**Re: First Federal Bank - Drainage and Grading Plan  
Engineer's Stamp dated 4-20-05 (J19-D43A)**

**Re: First Federal Bank -Drainage and Grading Plan  
Engineer's Stamp dated 3-29-05 (J19-D43A)**

GRADING PLAN

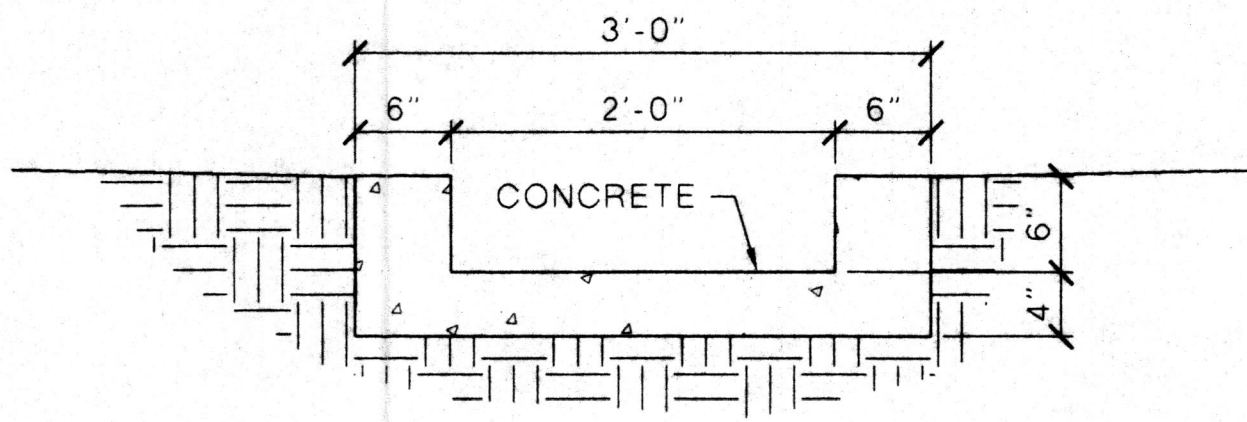
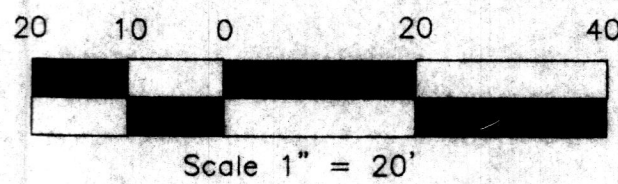
- Provide invert elevations for sidewalk culvert
- Add applicable S019 Permit notes.
